Application for a Non-Material Amendment Following a Grant of Planning Permission

Detached two-storey commercial unit with associated access

CA/22/01962

Re-arrangement of location of internal staircase to first floor and subsequent relocation of external fire escape.

DATE 10-11-23 DRAWING No. WM/701/NM

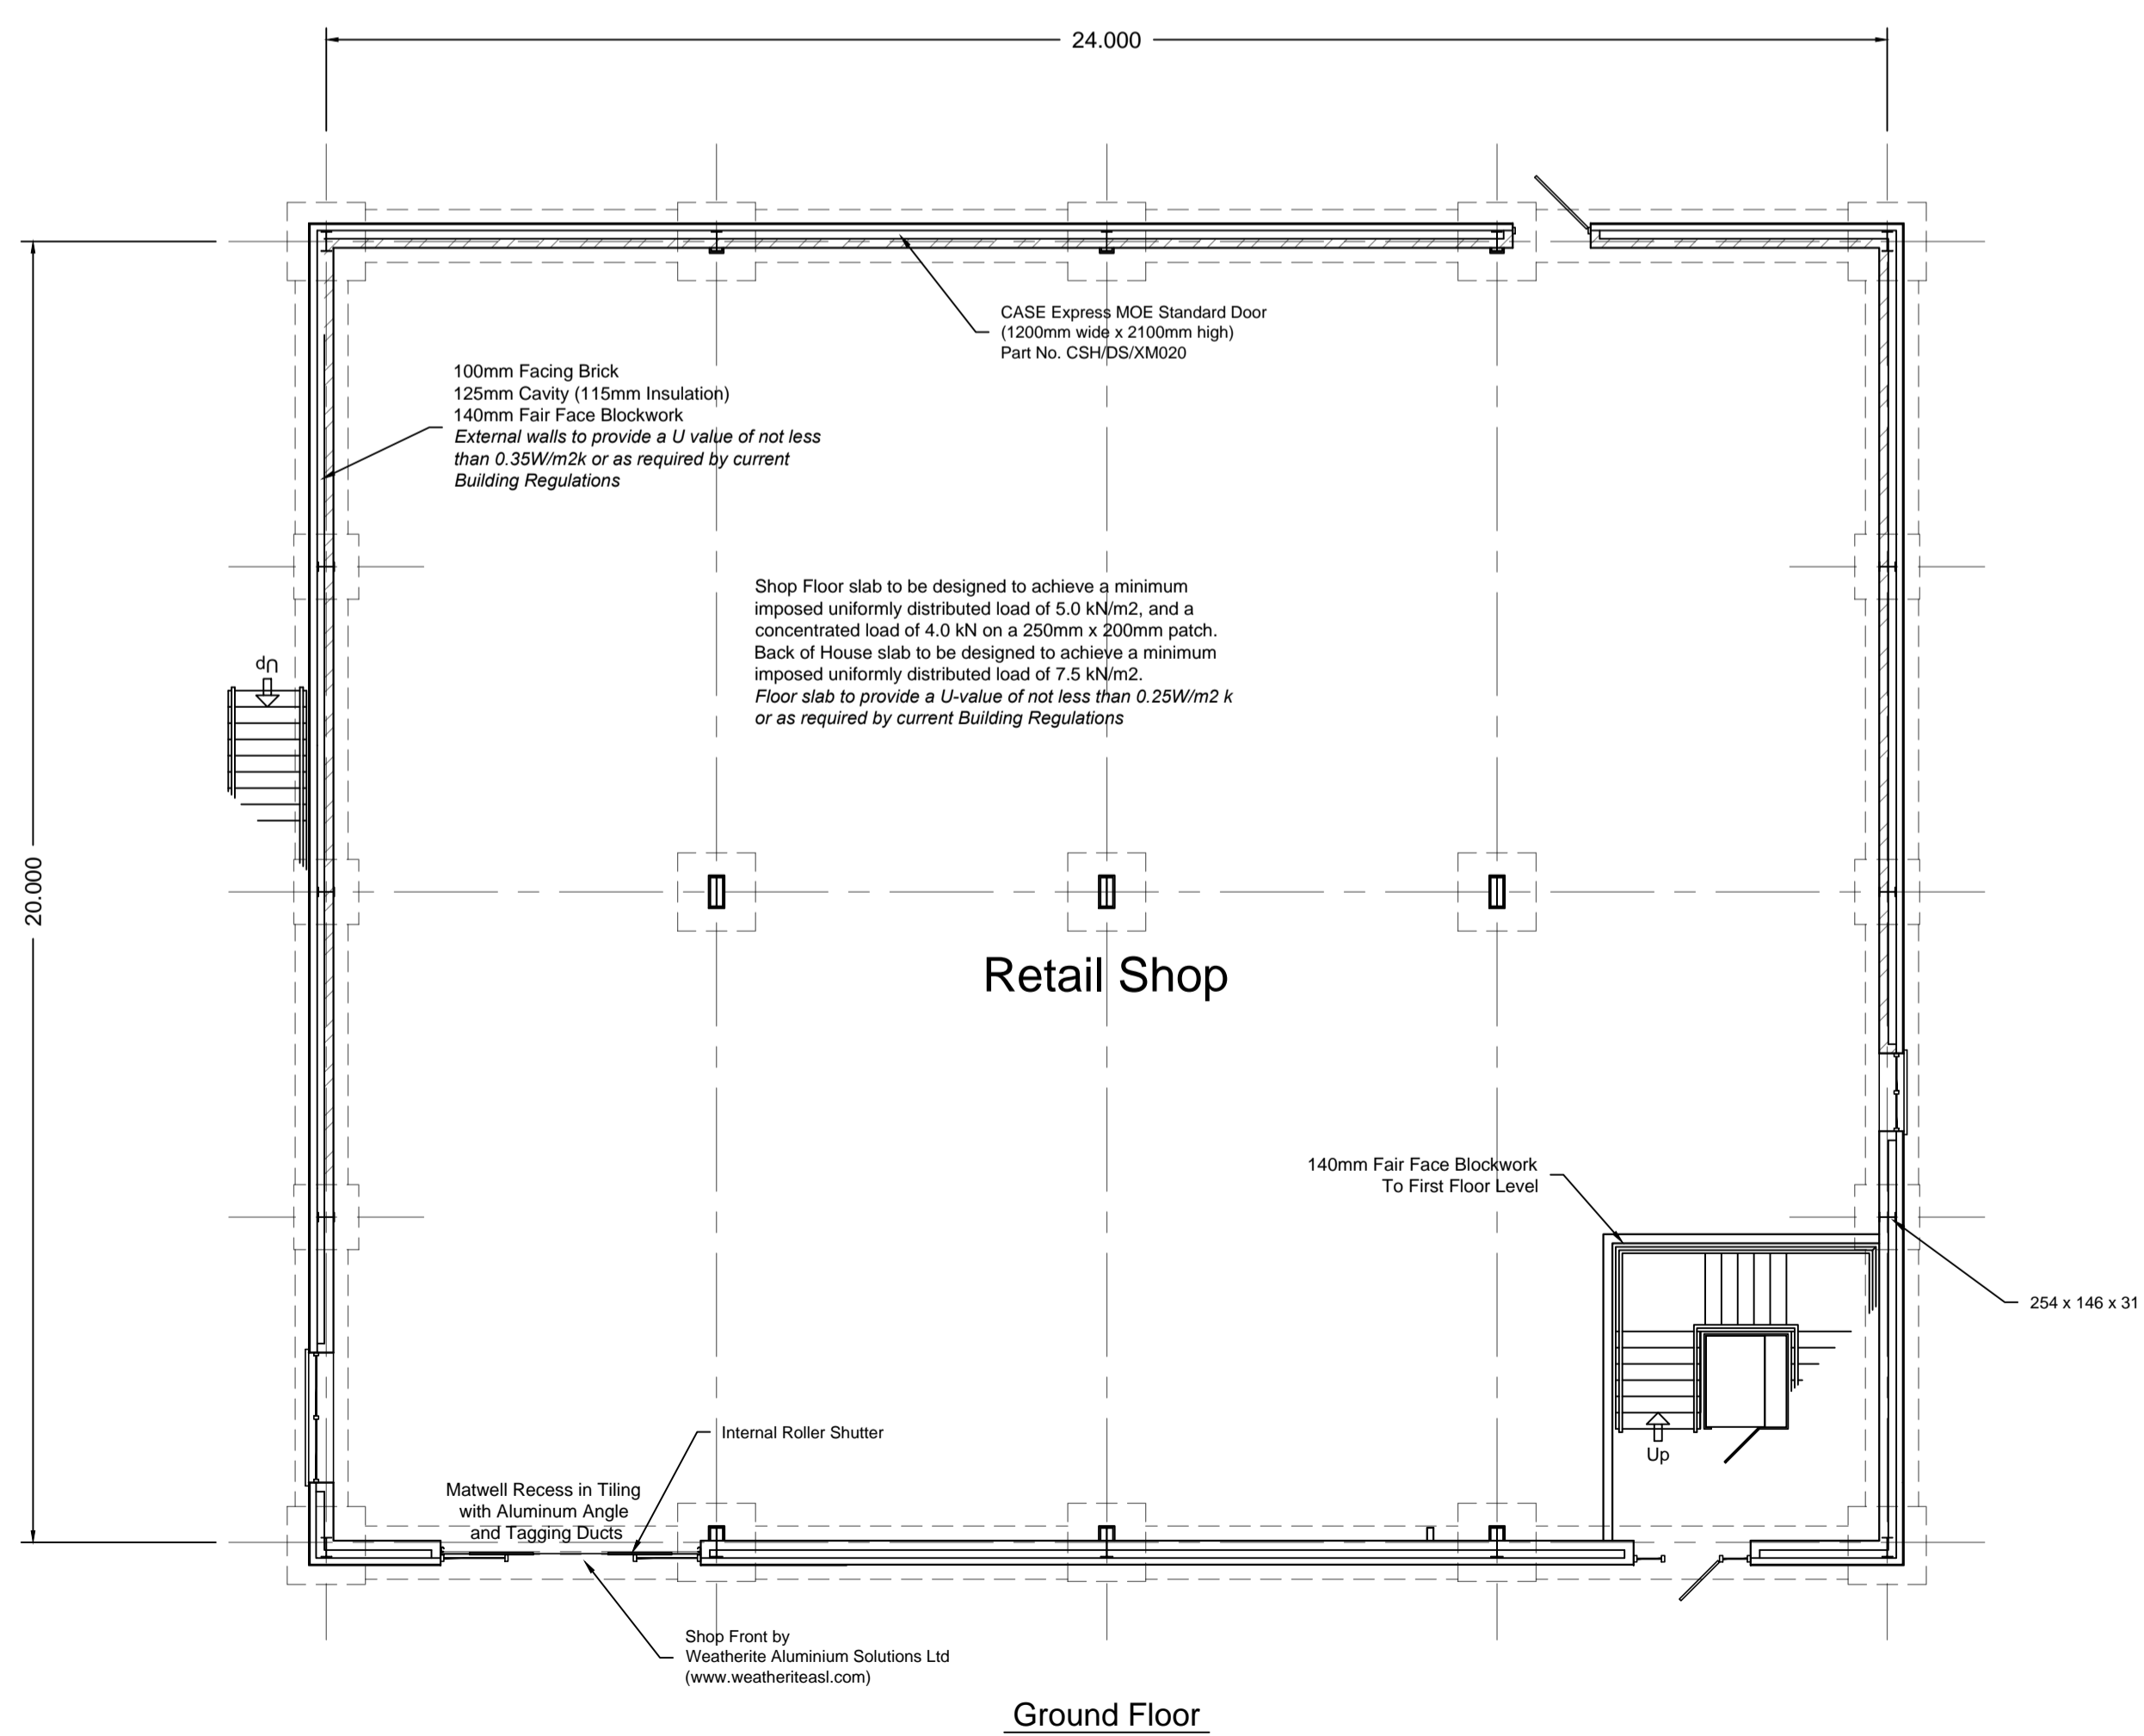
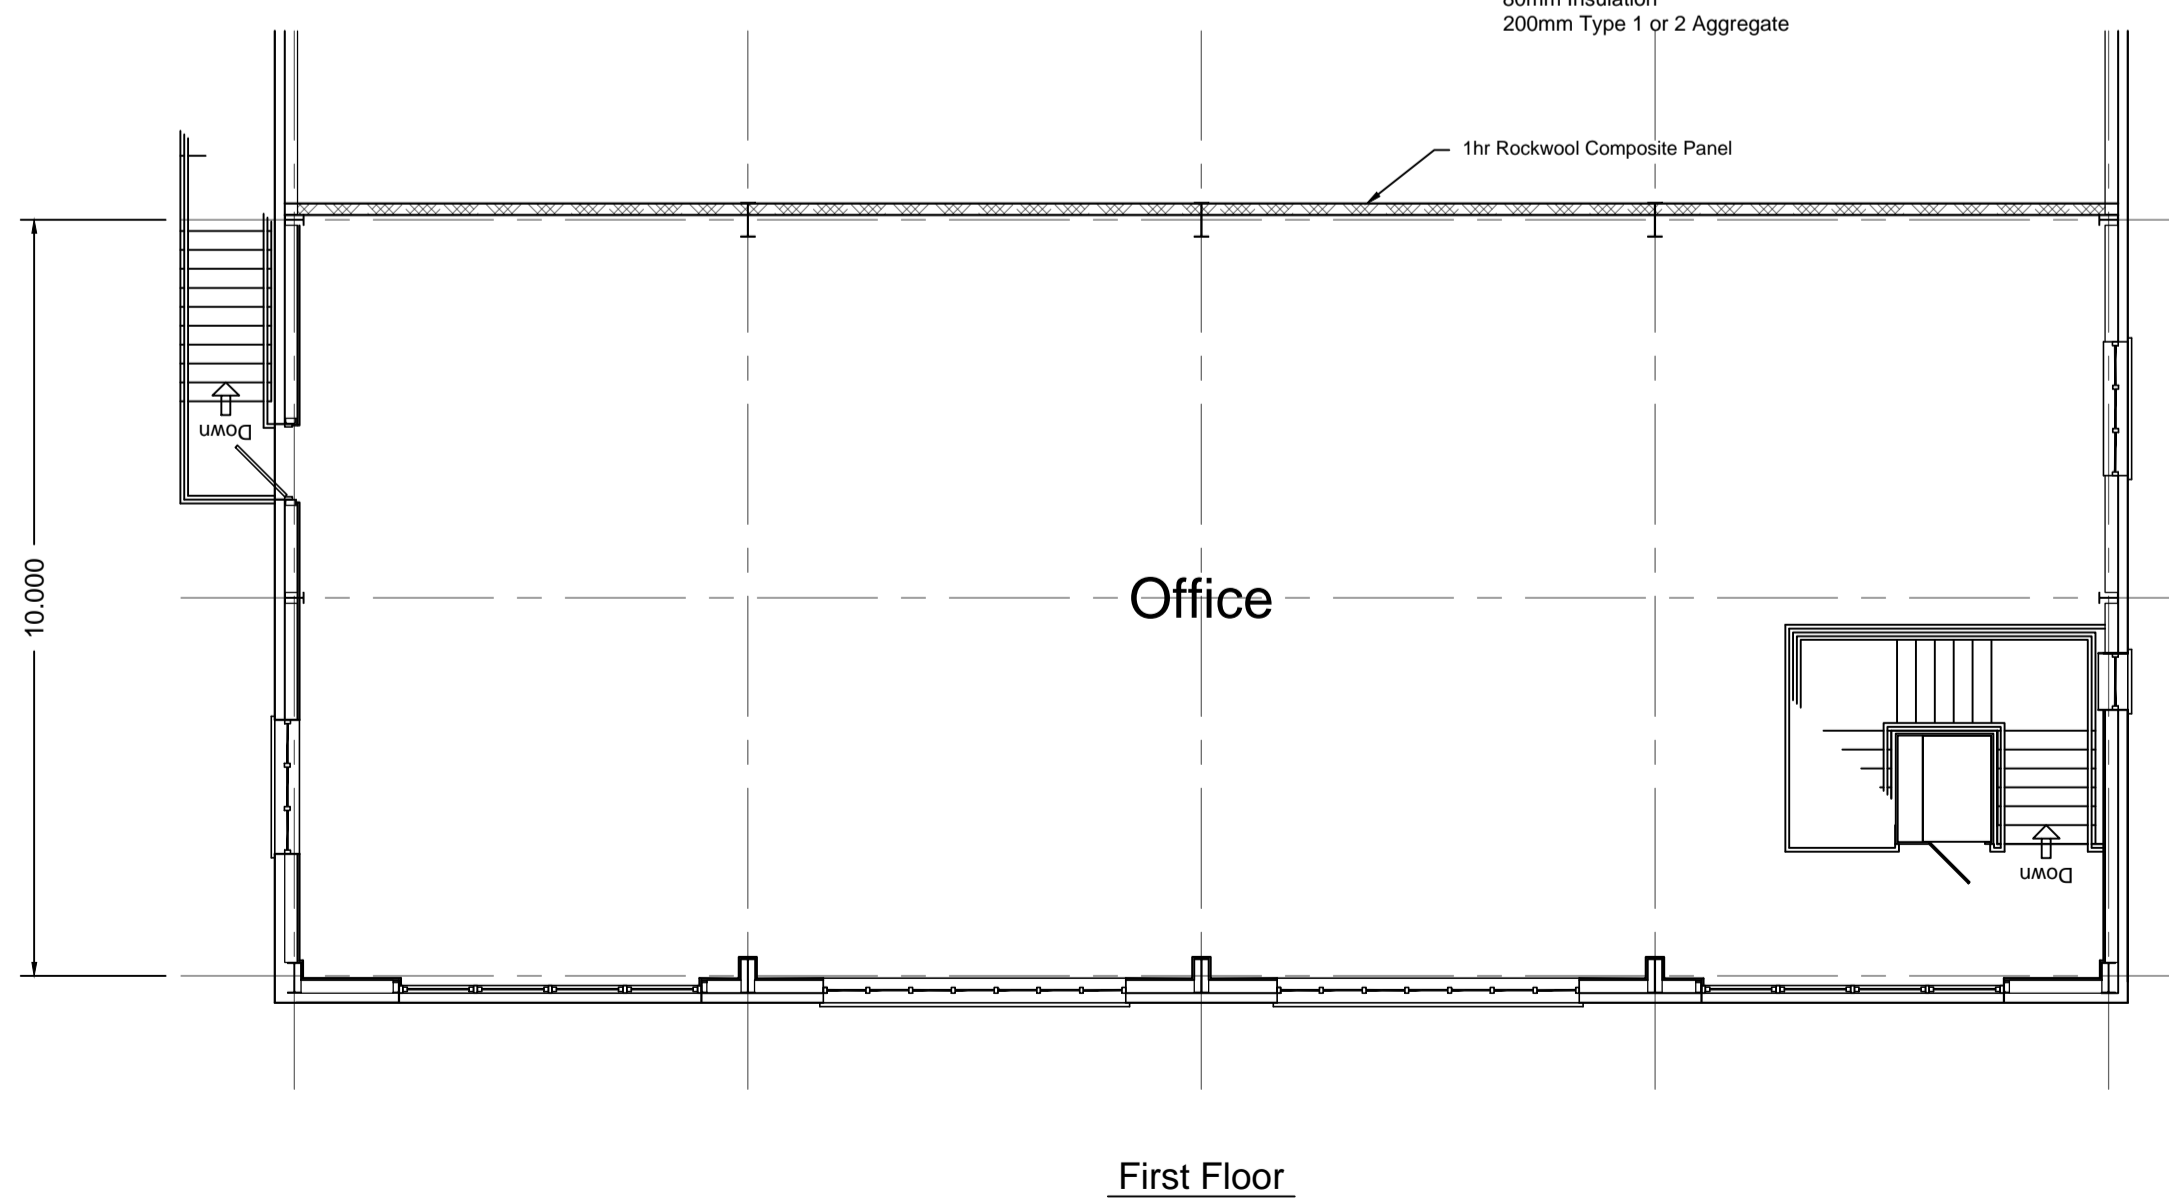
Creation of offices at first floor as opposed to café

Formation of larger retail unit at ground floor

To relocate the entrance to the first floor offices away from the "shopping precinct" and closer to the non shopping parking area.

The café was to have been part of the shop and the increase in retail area at the ground floor has enable office space to be provided on the first floor
